Ref: Planning application No: EP/2/21/HH

I am writing to object to the proposed planning application for 27a Sea lane East Preston to build a balcony to the rear of the property which will overlook neighboring gardens, invading the privacy held for many years by the residents.

Rear Elevation (east)

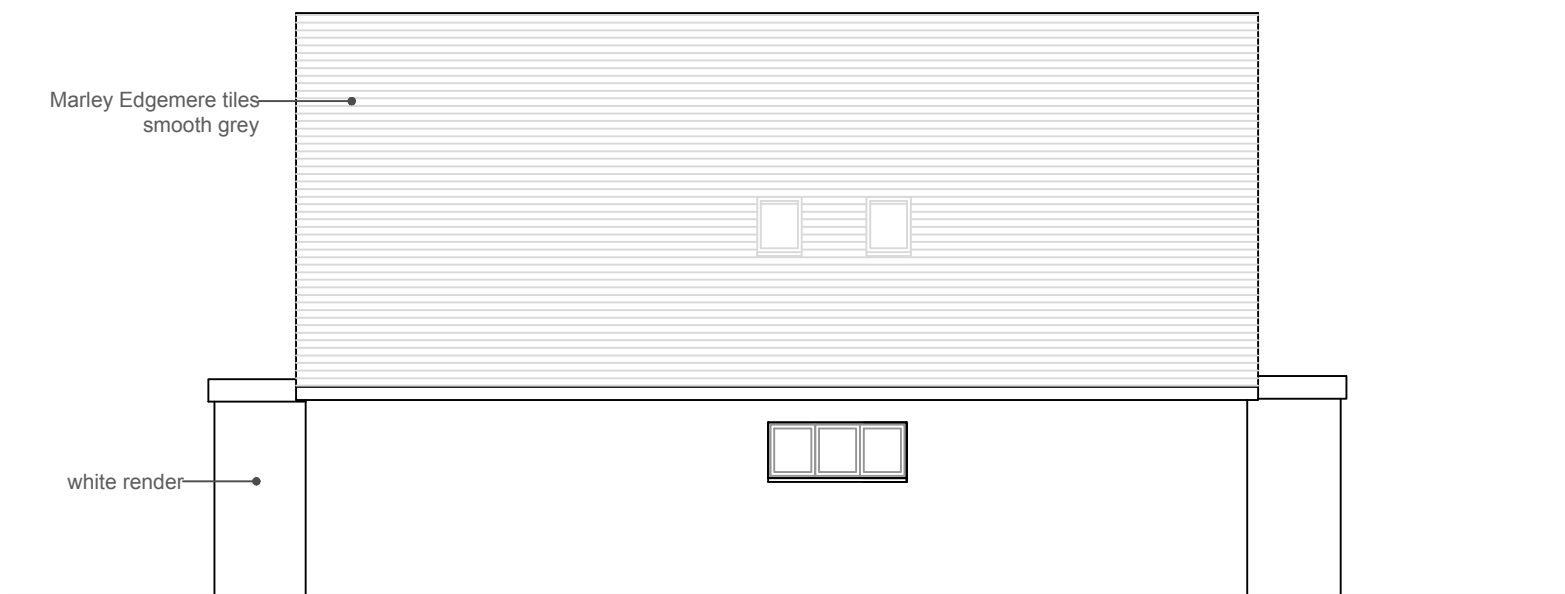
The application itself only mentions a balcony and alterations to the front of the property, yet the plans show a new balcony to the rear also? Surely this must need planning permission too?

The balcony will be visible from our day room and garden, therefore giving clear sight to anyone using the balcony, of us enjoying our garden, and indeed into our home if the bifold doors were open.

We strongly suspect that the intention is for a holiday let, with no thought for the privacy of neighboring properties. There would be no view to be had from the balcony, apart from overlooking private homes and gardens.
